Our ref: HA/2025/126811/01-L01

Date: 12 June 2025

**DEMOLITION OF EXISTING GARAGE AND ERECTION OF MIXED USE BUILDING
COMPRISING WOOD WORKSHOP TO GROUND FLOOR WITH SINGLE, SELF-
BUILD DWELLING ABOVE.
LAND ADJACENT 18 QUEENS LANE ARUNDEL BN18 9JN**

Project: Queens Lane Arundel BN18 9JN		Michael Forward, ARB, RIBA 150 Earlsfield Road, London, SW18 3DT Tel: 07773967775	
Drawing Title: Proposed North Elevation			
Scale 1:100@ A4	Date 05/05/2025	Drawn MF	Checked MF
Drawing Number N/A	Rev.	Project Number 1024

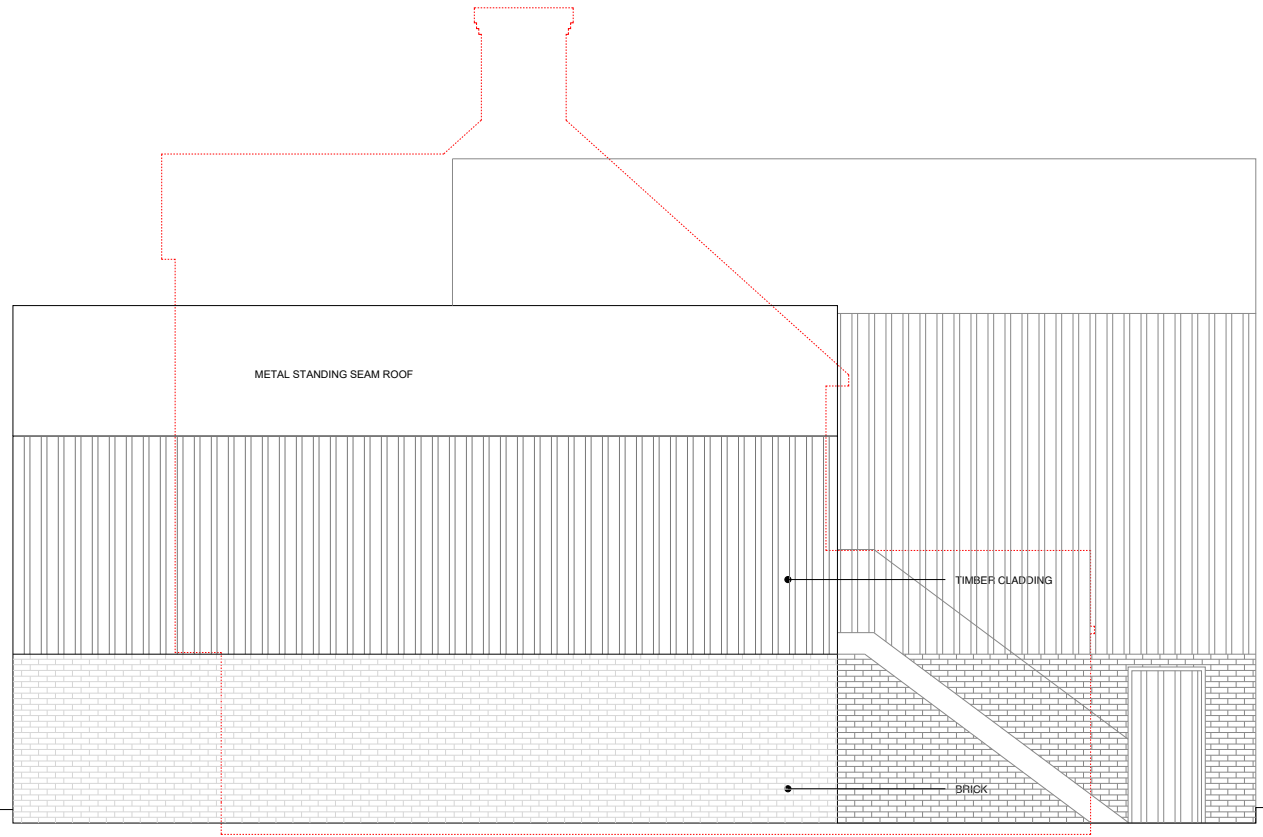
We note that the site already has planning permission for 2 dwellings with a very similar design, and the proposed development reduces the number of dwellings in Flood Zone 3 to one. The proposed development will only meet the National Planning Policy Framework's requirements in relation to flood risk if the following planning condition is included.

The development shall be carried out in accordance with the submitted flood risk assessment (ref 13341 April 2025) and the following mitigation measures it details:

- Finished floor levels for all living and sleeping accommodation shall be set no lower than 4.1 metres above Ordnance Datum (AOD)
- The ground floor areas shall be designated exclusively for Less Vulnerable uses.

These mitigation measures shall be fully implemented prior to occupation and subsequently in accordance with the scheme's timing/phasing arrangements. The
